**Planning application no: 3/2013/0737**

**Proposal: Residential development of up to 62 dwellings.**

**Location: Hanson Garden Centre, Whalley Road, Barrow BB7 9BA.**

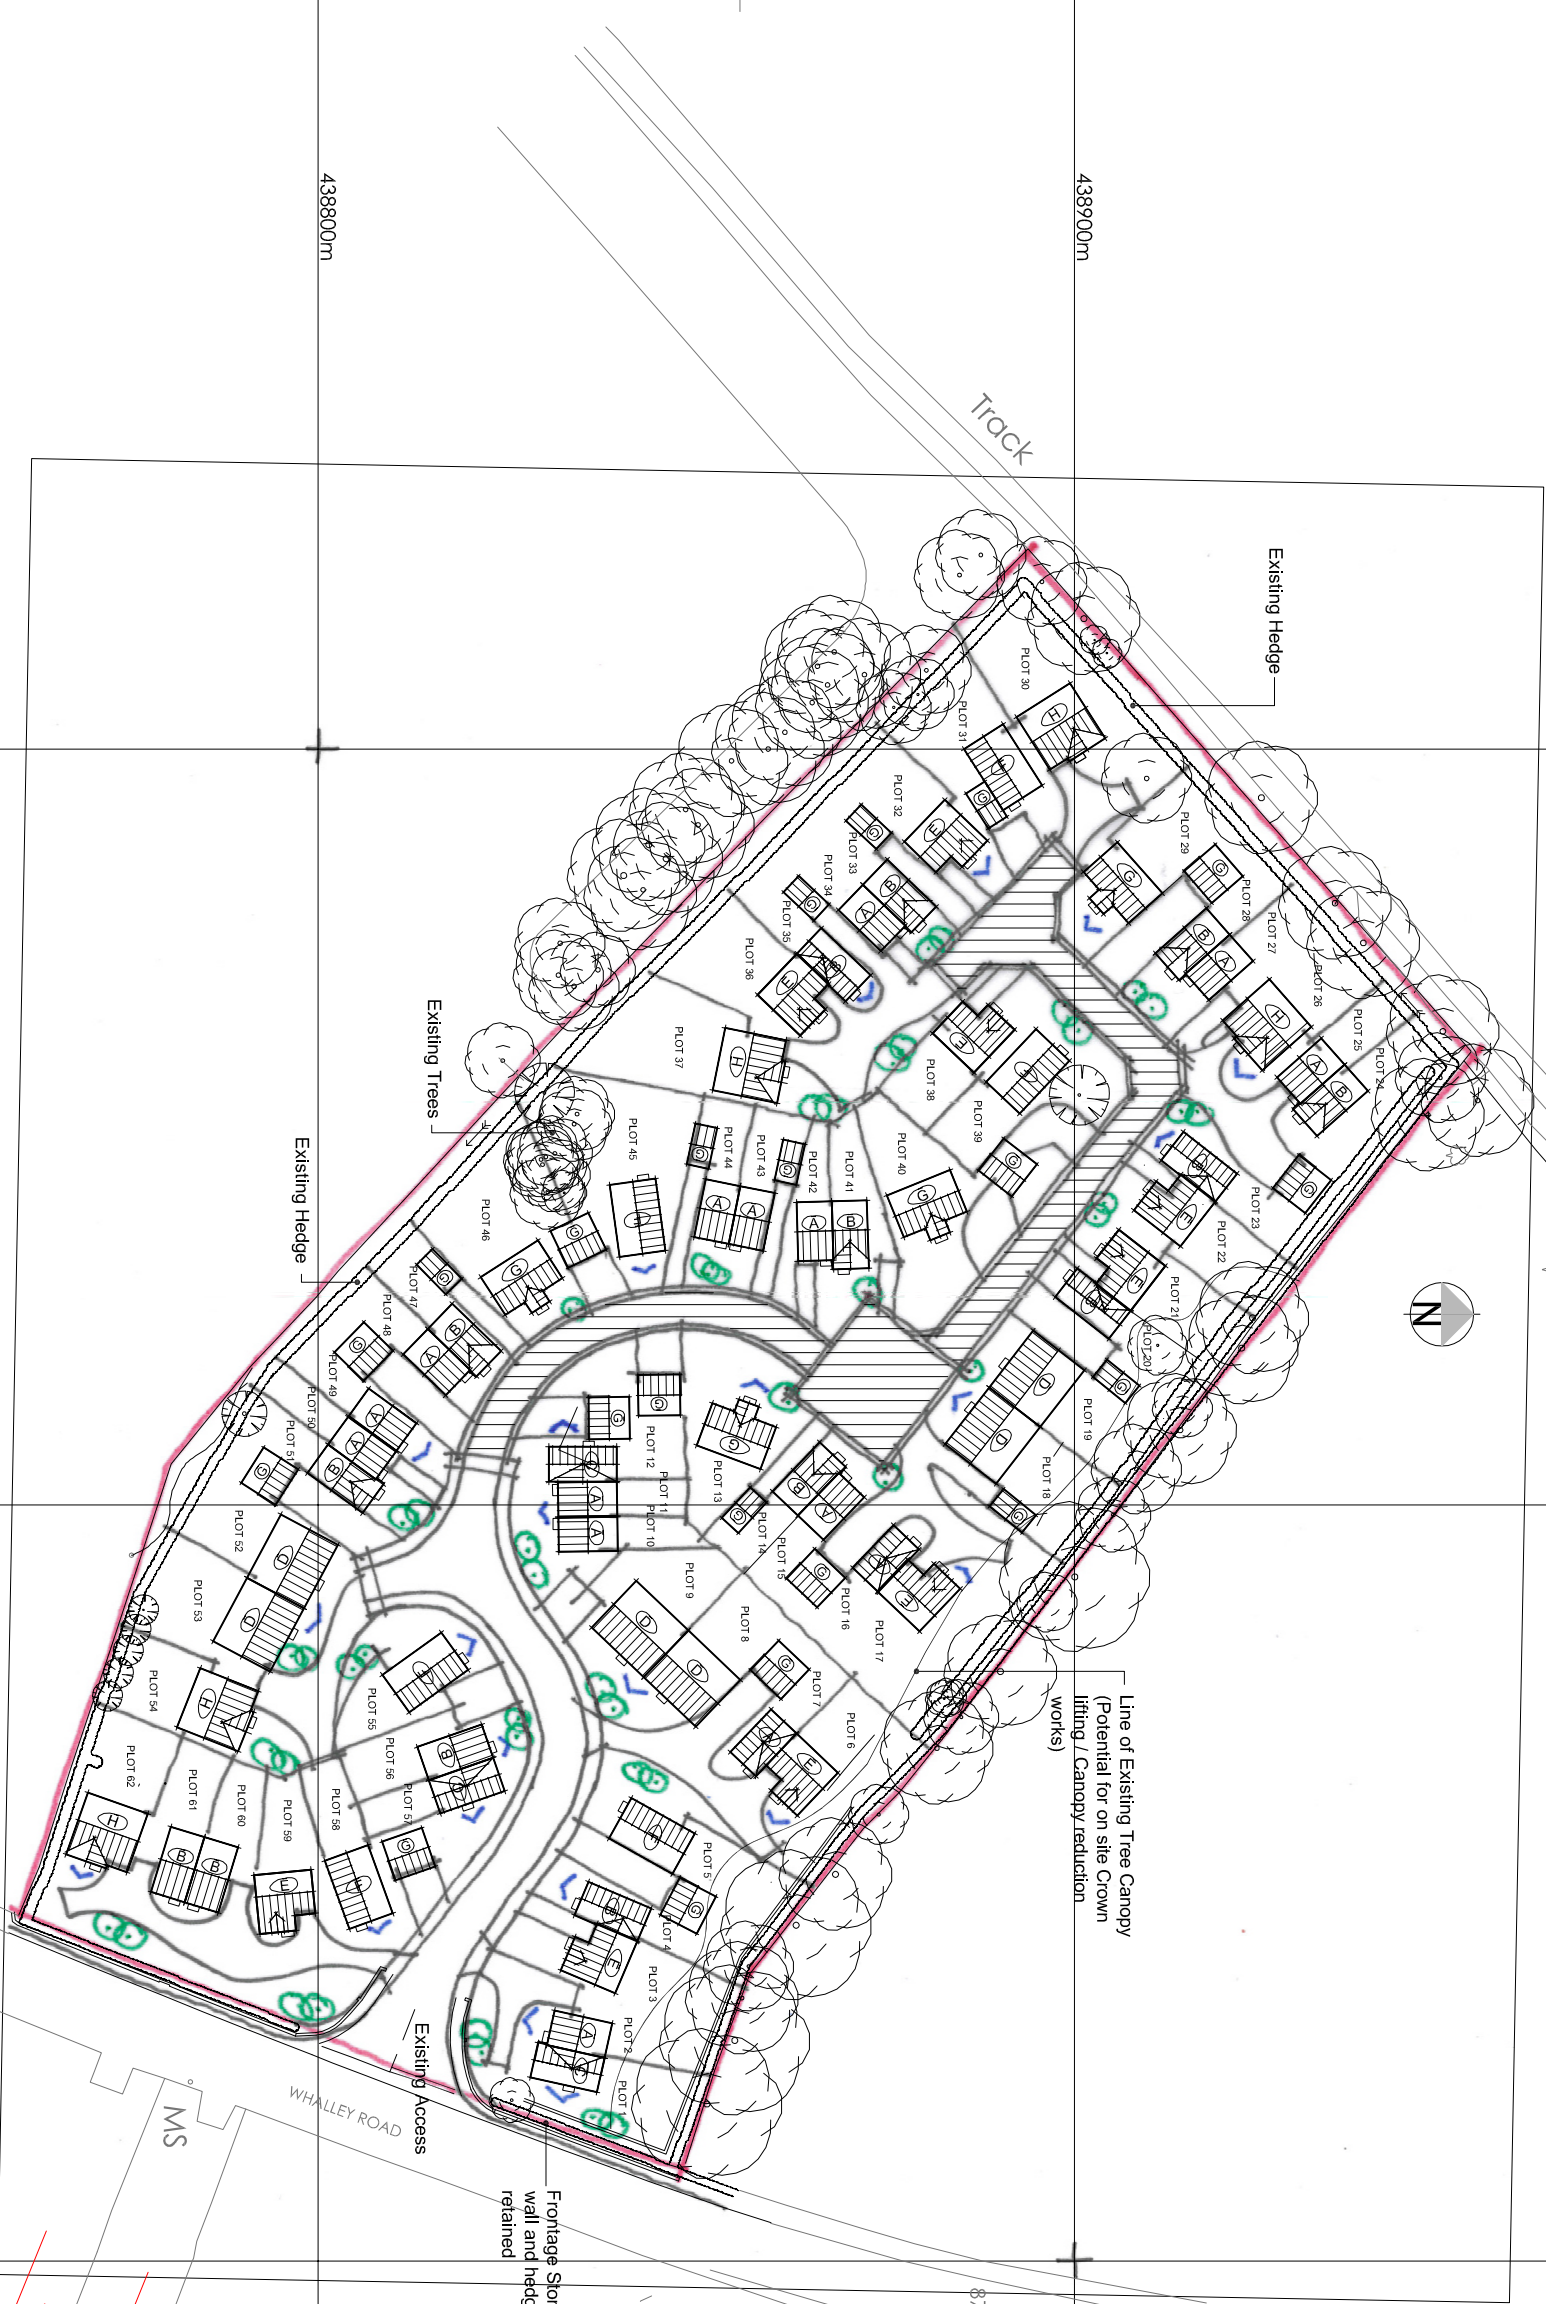
The indicative layout (SK\_01) shows the distance from the most distant dwelling to the junction of the estate road to the Whalley Road junction is about 250m. To comply with a 400m maximum walking distance to a bus stop, the north and south bound bus stops should be no more than 150m along Whalley Road from the access.

The proposed access for the residential development is based on the access used for the garden centre. The geometry and size of this access is not appropriate for the residential development. I would ask that the access should be at least 5.5m wide or the same width as the estate road carriageway. 6m radius kerbing should be used to form the junction with Whalley Road.

Visibility splays along Whalley Road should be 2.4m by 70m.

Footways along the estate roads should be a minimum of 2m wide. Where footways are not to be provided, service strips 2m wide will be required along both sides of the carriageway.

The surface treatment / landscaping of the 'square' should be designed to make it clear where through vehicles should drive.

On-site parking should be provided in accordance with the parking standards. Parking spaces should be 2.4m by 5m. Where the parking space abuts a wall, the length should be 5.5m. Parking spaces should not be partially placed within a service strip.

Garages should be 3m by 6m. If separate provision is made for the secure storage of bicycles under cover, then the garage may be reduced in size.
